Your Ref: OWPC16467
Our Ref: A/190/17/HH 17-10-2017
Please ask for:
Mrs A Gardner

Erection of single storey detached double garage
Harcourt West Drive Angmering

DRAWING	PROPOSED SITE PLAN AND ELEVATIONS																						
Date	October 2017	Drawn By	PJC																				
Scale	1: 200 - 100 @A3	Iss. App. By	DKC

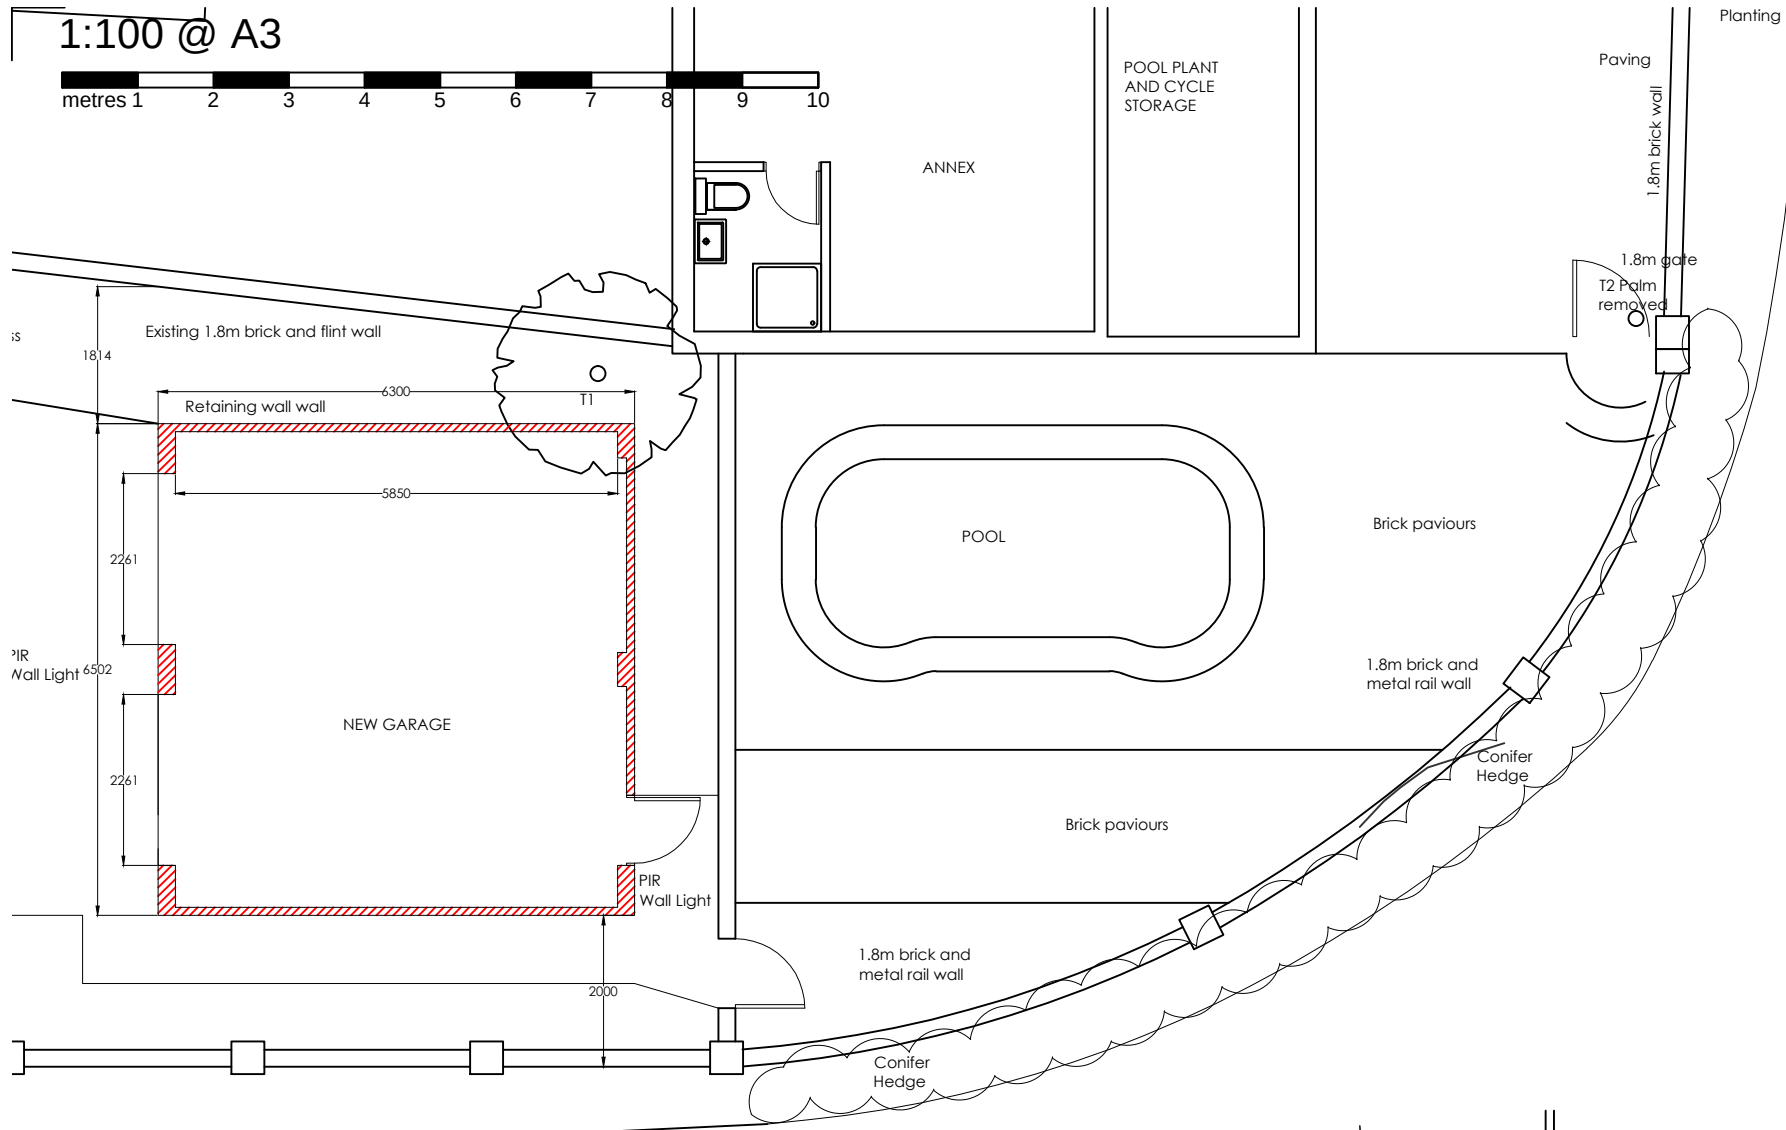
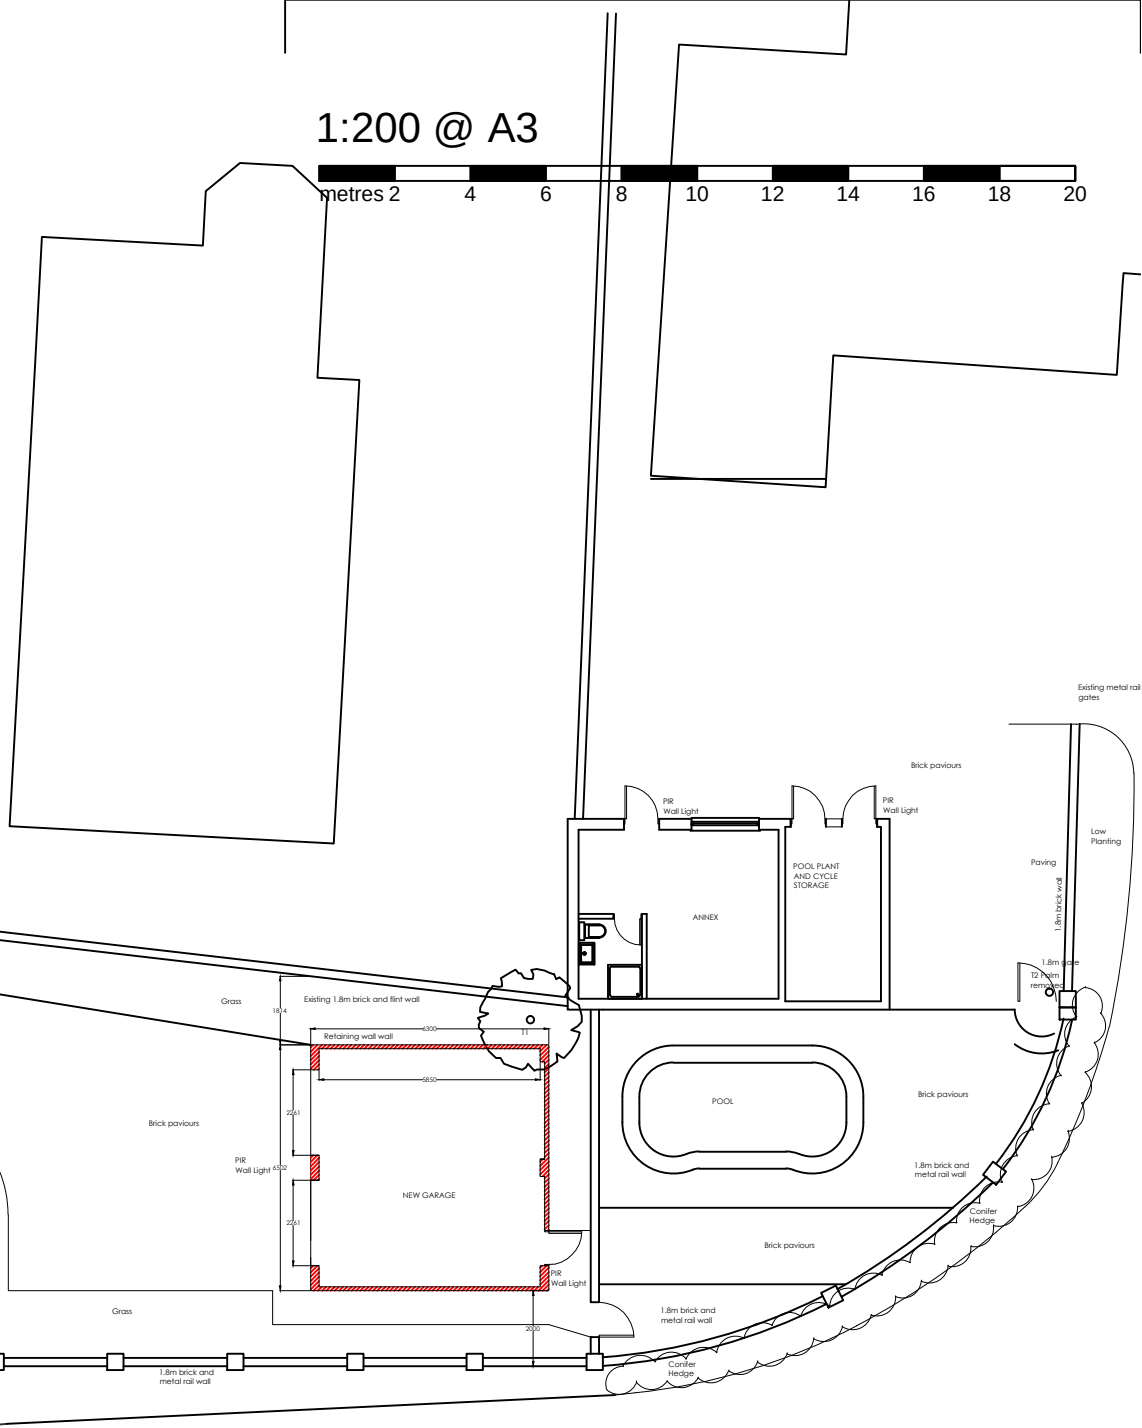
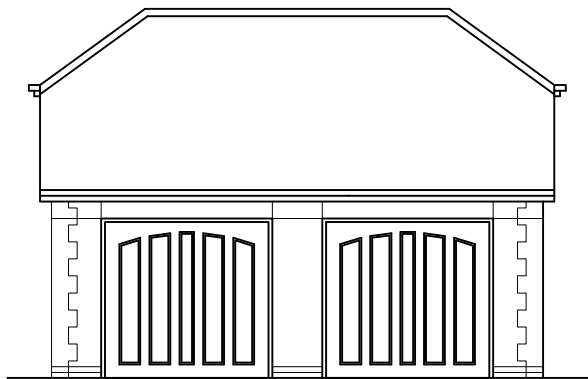
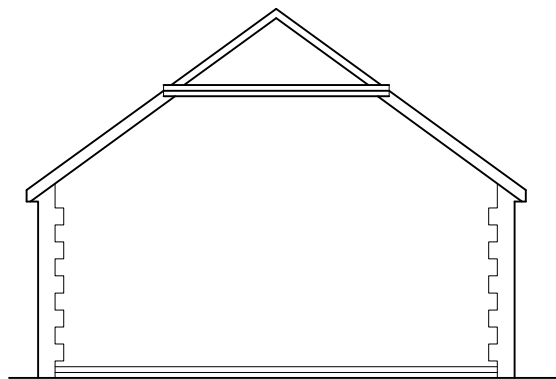
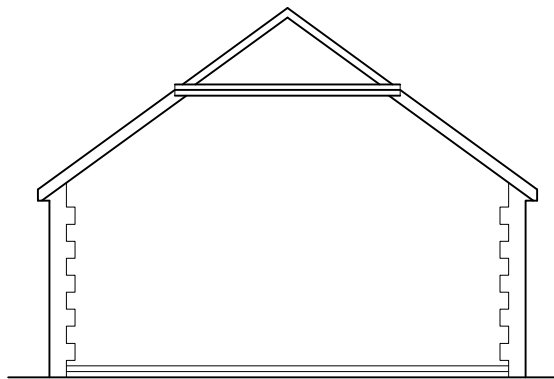
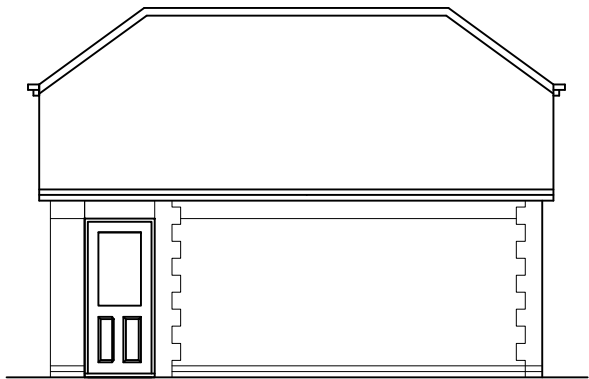
I object to the proposal for a massive (height not provided) double garage and driveway which will obliterate a garden area that the neighbourhood has enjoyed for many years as a neatly kept green space. Well-tended until more recently when it became a home for weeds punctuated by infrequent attempts at quick clean-ups

Construction of a double garage and long driveway will completely change the street scene of West Drive. It will diminish the open, scenic character of the area; something I understand would be in contravention of the local plan. Approval of this application has the capacity to open the floodgates to any and all desires for garage extensions, building of sheds, porches, conservatories, parking spaces and what have you on the open spaces of the Ham Manor neighbourhood which is supposed to be kept as a landscaped area.

And what about flooding? The garden area currently provides a crucial soakaway for all the rainwater that comes down off the slope of the New Road area on to West Drive. Building over this space will surely make matters worse - West Drive already floods when it rains heavily. My house insurance company raised my premiums telling me it's due to "surface water flooding "on West Drive. By the way, my house is about two metres higher than West Drive, something I pointed out to the insurance company to no avail. They held fast to their maps showing surface water flooding so any claims to the contrary are spurious. It's a flooding area. Surely the planners don't want to allow development that makes flooding worse?

The garage is too near the foundations of my house; giving me cause to worry about the stability of my dwelling. The garage will also plunge an area of my back garden into permanent, deep shade.

The exit from the driveway which the application has running the length of the garden will be awkward not to mention unsafe. There is a lot of car and truck traffic to and from the
